**WEST SUSSEX COUNTY COUNCIL
PLANNING SERVICES CONSULTATION**

SUBJECT: AL/136/17/PL - Erection of pair of semi detached houses & new access onto A29

Land West of Fontwell Avenue, 1, Fontwell Avenue, Fontwell, Eastergate, PO20 3RU

RECOMMENDATION: Advice & More Information

PROPOSED SITE PLAN 1:200

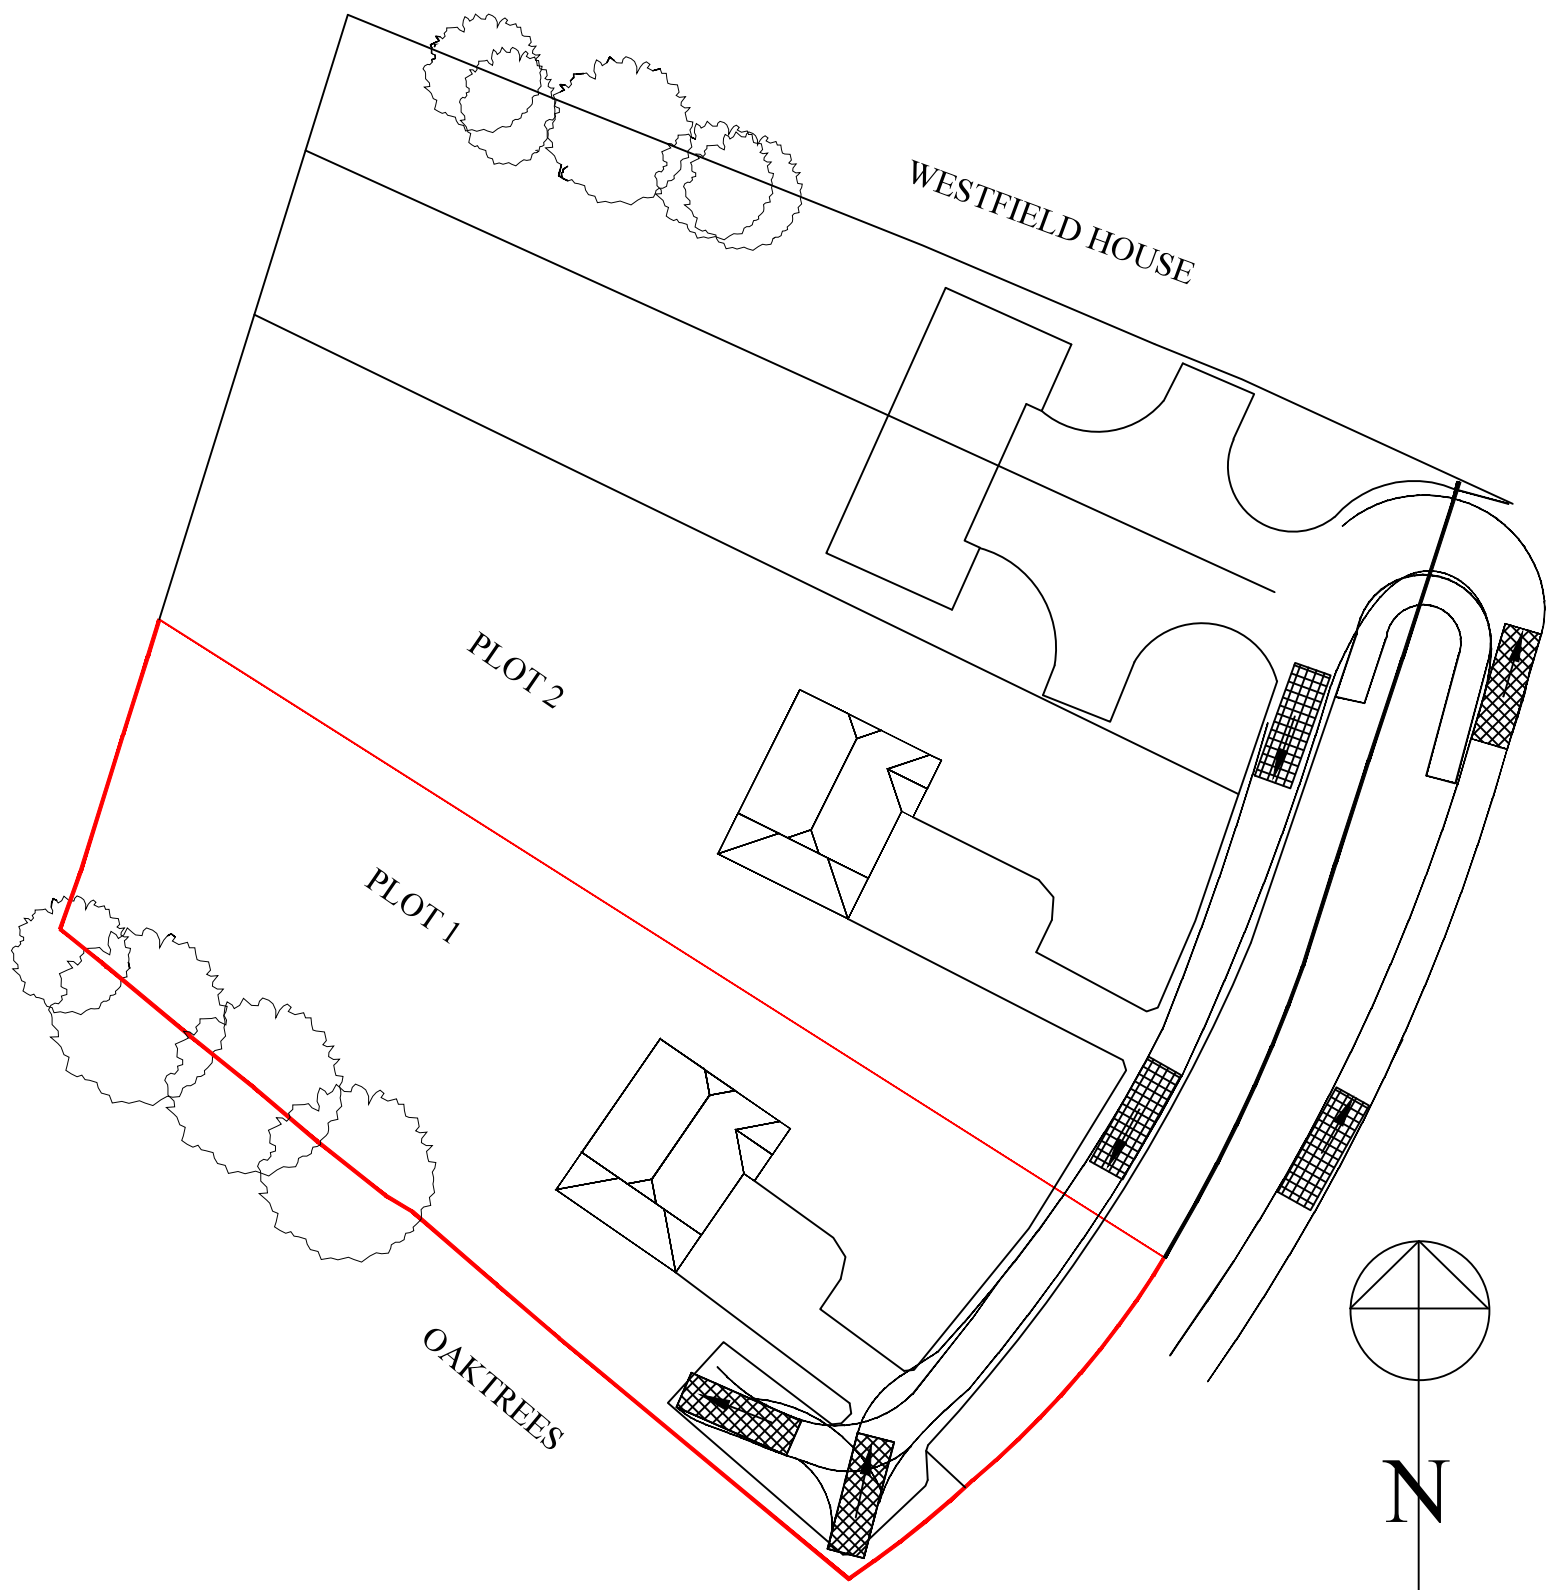
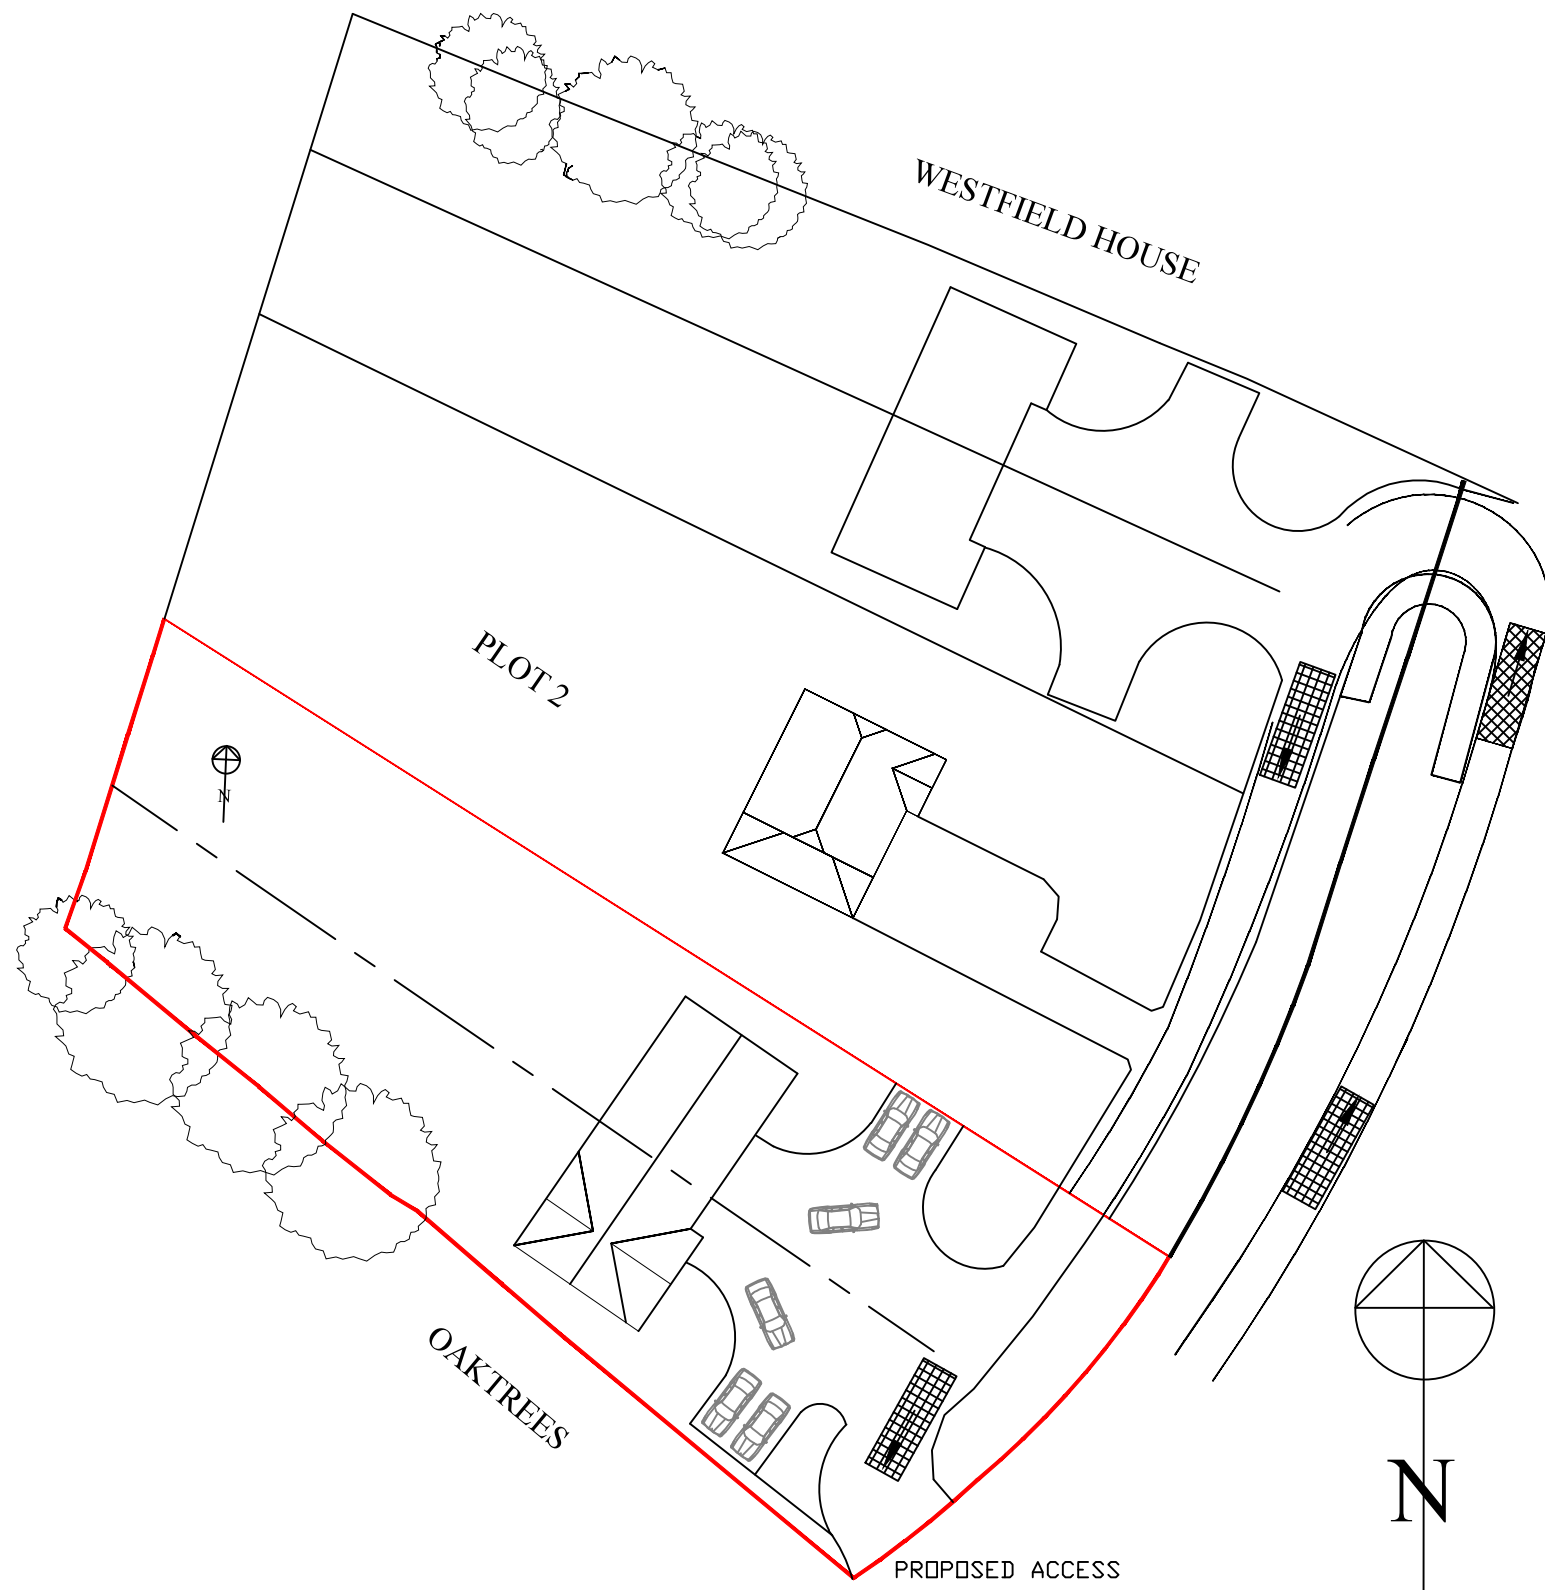
However this latest application also seeks the implementation of a secondary point of access at the southern extent of the site onto A29. This will result in all dwellings being able to make use of an in/out access arrangement.

It is noted that the previously approved turning area is now omitted and this in/out arrangement would 'in principle' mitigate against the loss of this provision. There would be no controls in place to ensure this point of access is used as an exit only as stipulated within the Design and Access Statement.

The applicant has however not demonstrated how this new point of access is afforded with appropriate geometries or visibility splays to ensure safe and suitable access to the site can be achieved.

Given the whole section of A29 fronting the site is now subject to a 30 mph speed limit it is not unreasonable to conclude that actual 85th percentile vehicle speeds will now be lower than the previously recorded 37.1 mph. Nevertheless I'm not aware that the applicant has provided more up to date robust data to conclude this with any certainty. Nor has the applicant provided details as to the exact location of where the historic speeds were recorded.

To the north (southbound traffic) I can ascertain that visibility splays of circa 2.4 x 50 metres is achievable wholly using land considered public highway. Some cutting back of overhanging vegetation may be required to form these splays.

This is significantly in excess of the splays required for the posted speed limit of the road (2.4 x 43 metres as per Manual for Streets Table 7.1). However this would fall short of the required splays for the demonstrated 85th percentile vehicle speeds from 2013 (2.4 x 59 metres).

Given the above I would be minded to request that the applicant provide further information to demonstrate that the proposed point of access is afforded with appropriate visibility splays to ensure safe and suitable access to the site can be achieved.

The applicant would be advised to undertake a new 7 day automated speed survey at the northern extent of the maximum achievable visibility splay for the proposed point of access. Alternatively demonstrate a how a minimum splay of 2.4 x 59 metre can be accommodated in the northern direction. This would have an impact upon the frontage boundary treatments vegetation but may intersect with areas outside the red edge plan provided.

The internal access arrangements are such that an acute turn is required at the site access point onto A29. The applicant should demonstrate with swept path tracking plans how the access point will work in practice for a private motor vehicle and other service / emergency vehicles that may need to enter the site.
